# **KITITAS COUNTY**

### **MEMORANDUM**

TO: All Staff  
FROM: Justin Turnbull, County Surveyor  
DATE: March 27, 2017  
SUBJECT: County Survey Review of Preliminary Plat LP-17-00002 (Suncadia)

SHEET
PP-02

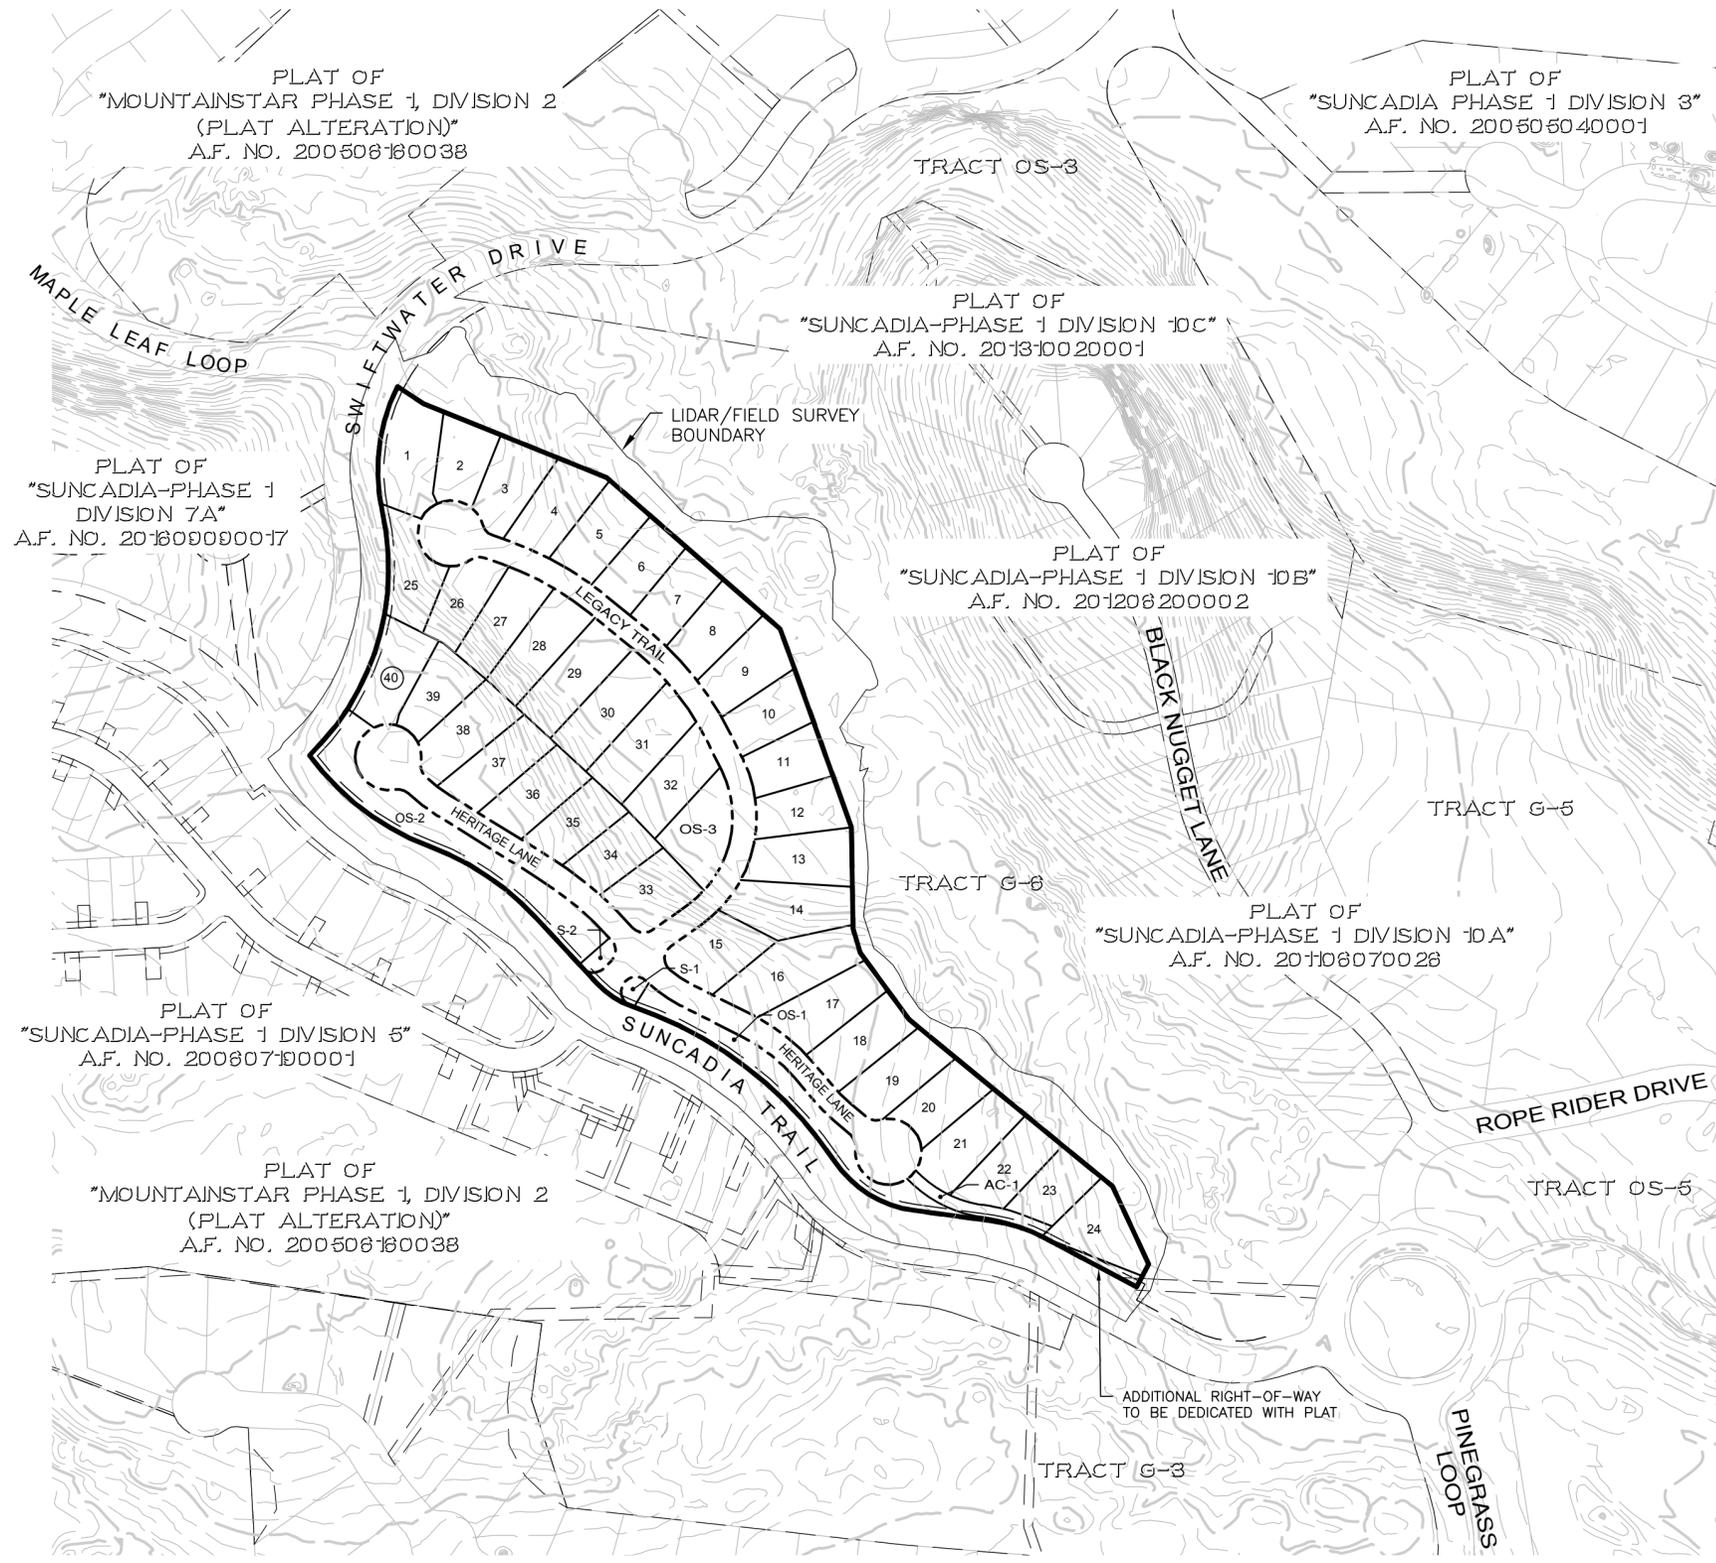
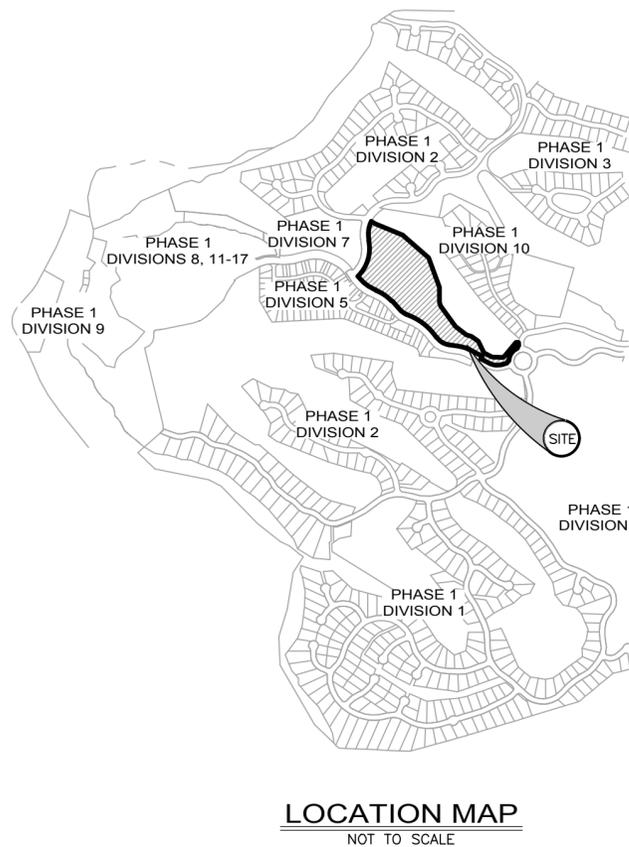
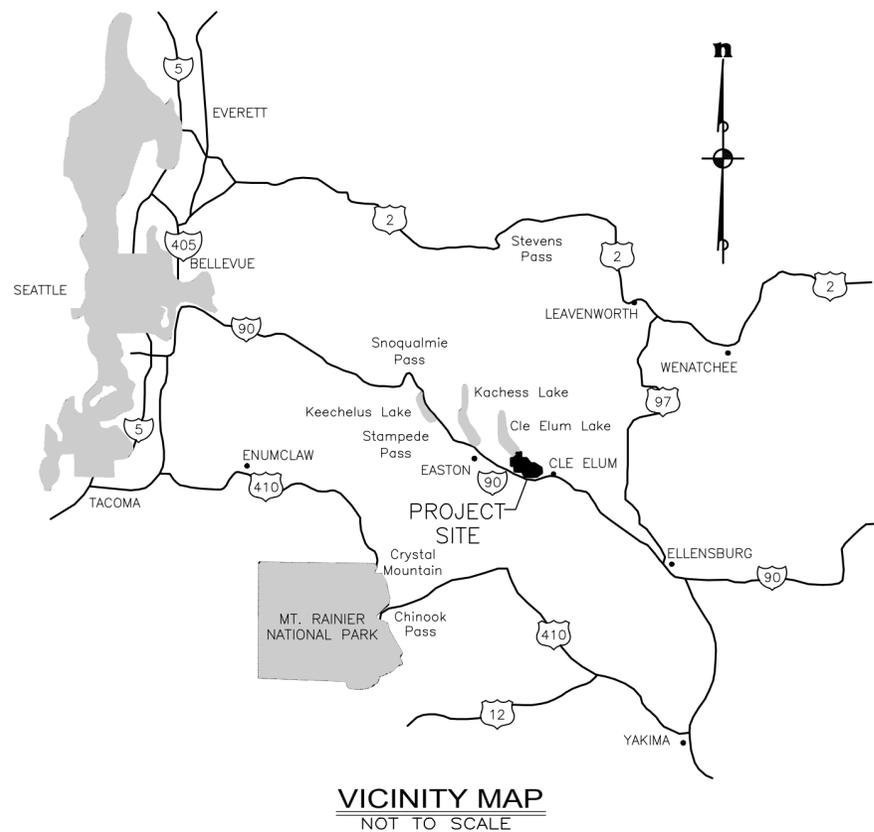
1. Lot and road dimensions to be shown on the face of the plat (KCC:16012.020(8)).
